MMC: FW: Shaws TCP (CMP)

Attached are our responses to the DPW's comments. Our approximate durations for each phase of work are as follows. Let me know if you would like any additional information.

FIGURE  
**2A-1**

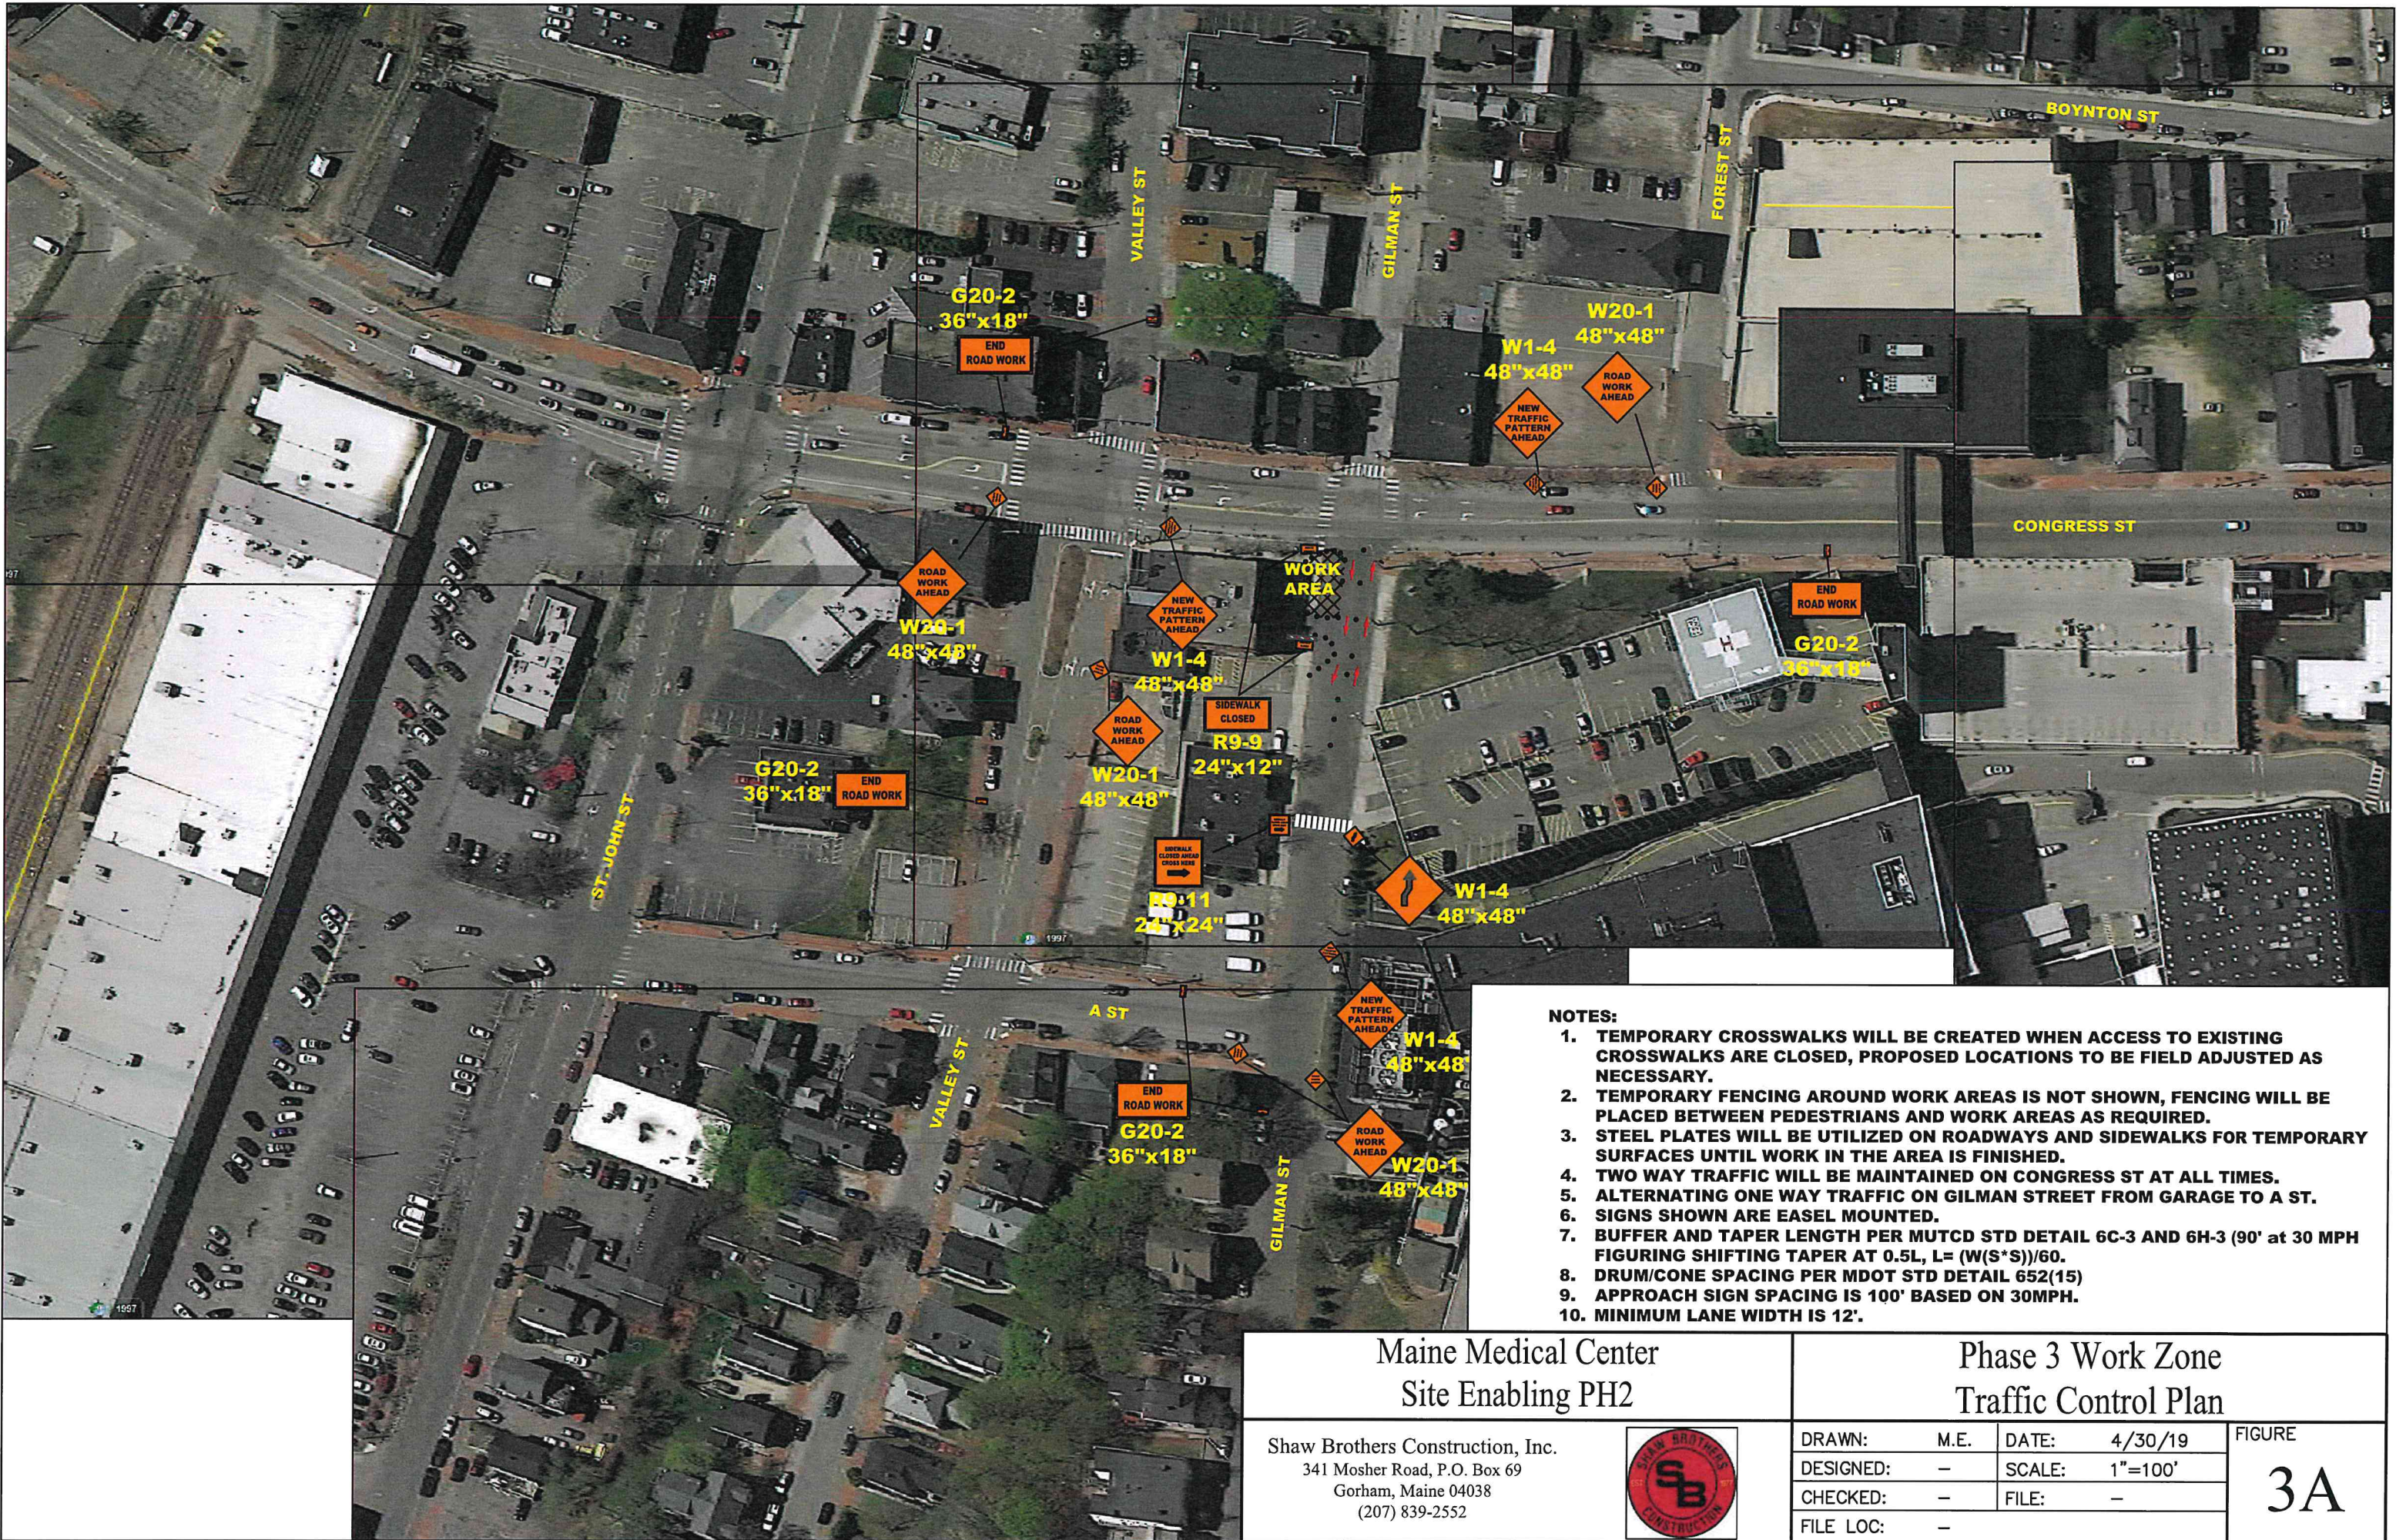
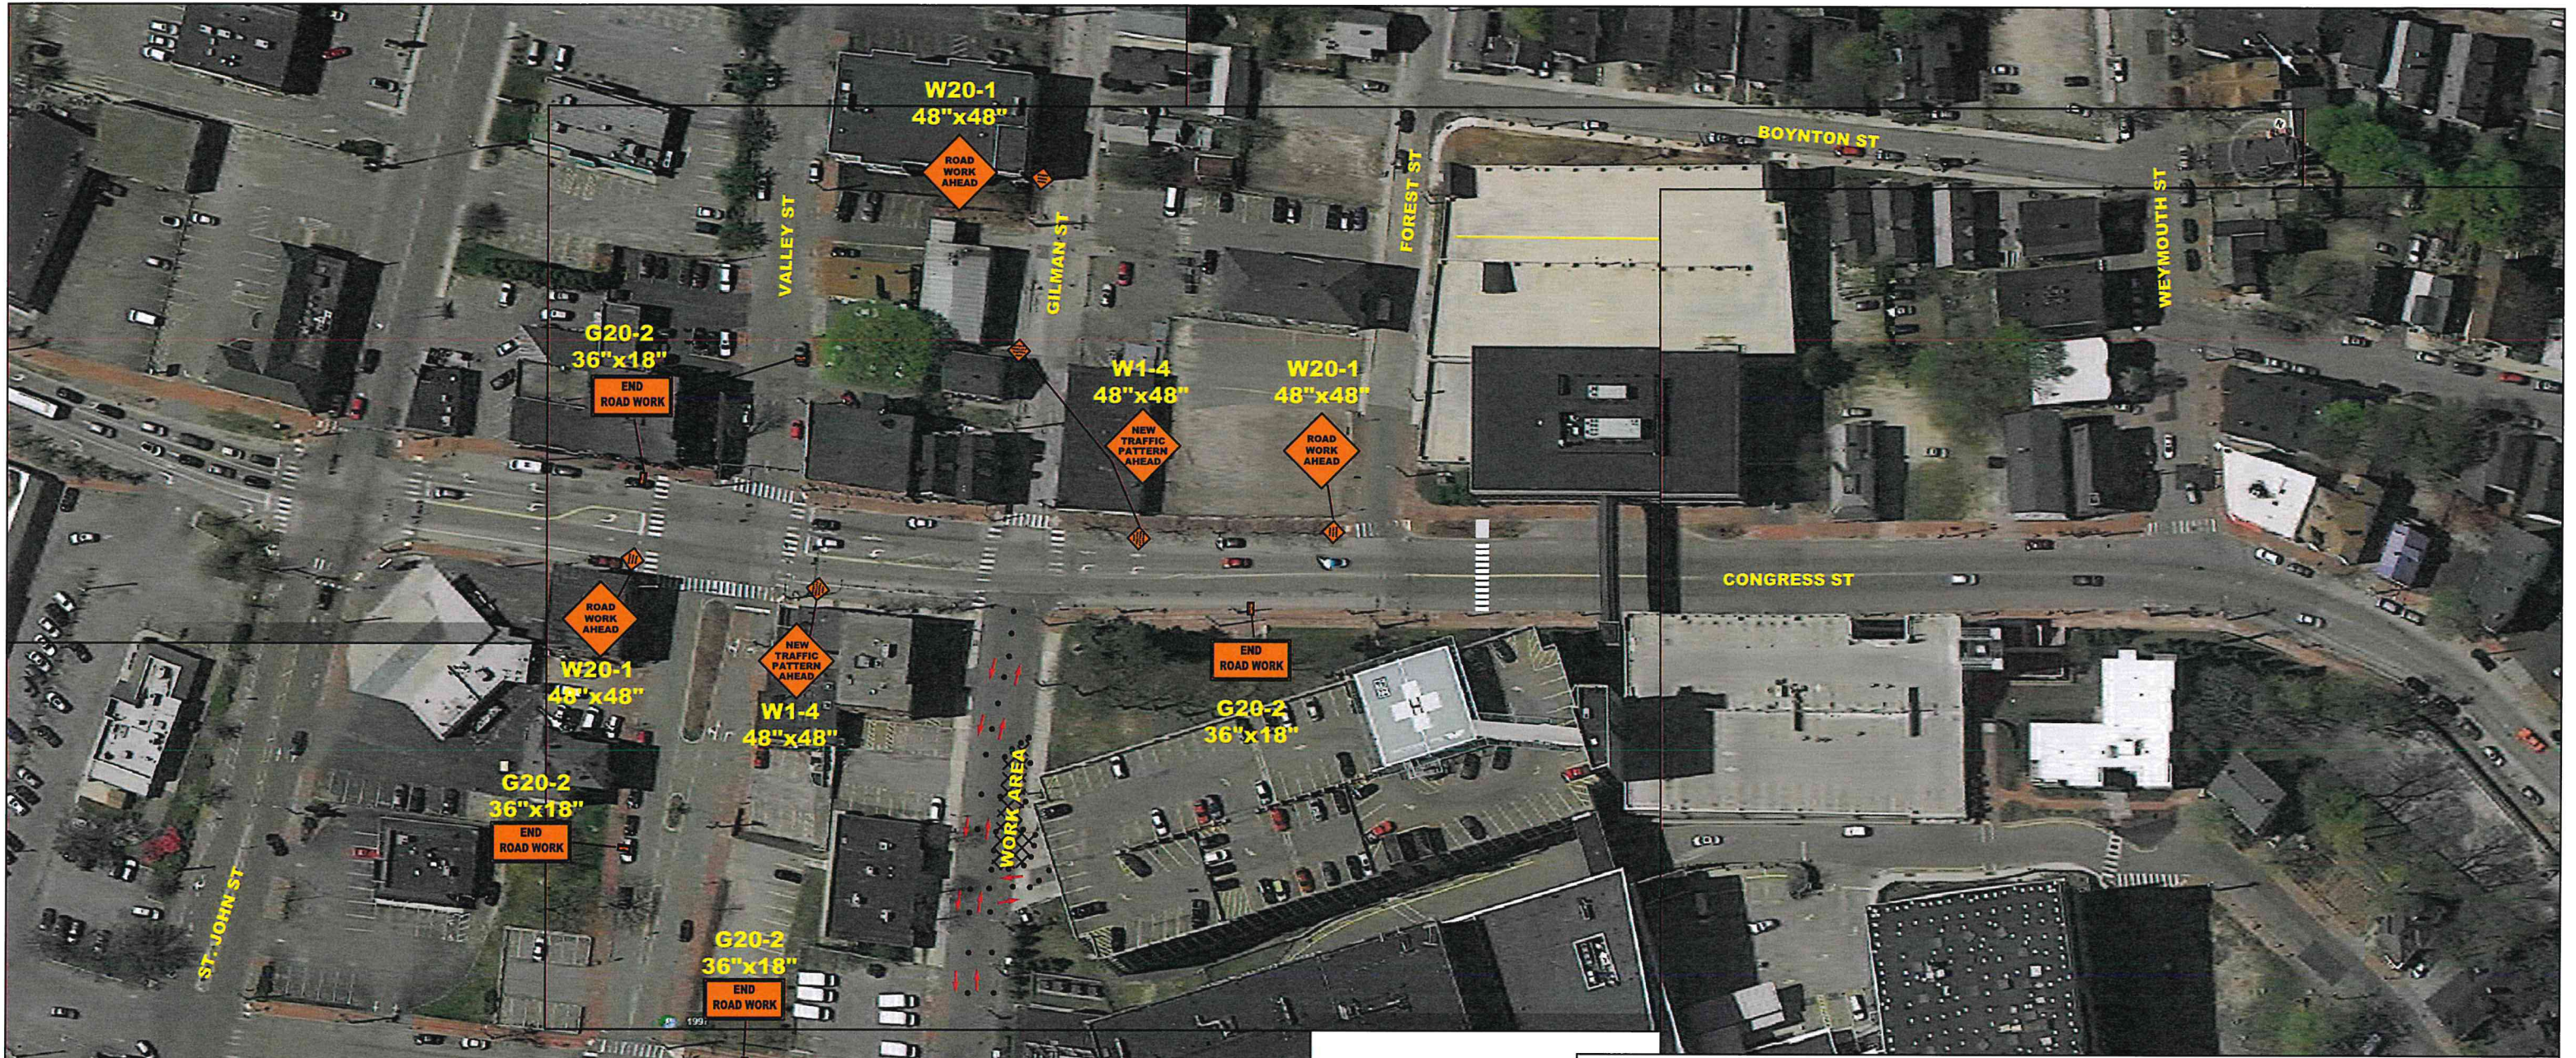
One basic comment from Tom Errico was re labeling the Shaw graphics with approximate timelines, but I don't believe this has been addressed (unless I'm missing something?). We do have timelines in the Turner documents, but these don't match up entirely with these plans. Can you guys address this quickly?

Phase #1: 3-4 weeks

Phase #2: 8-10 weeks

Phase #3: 4-6 weeks
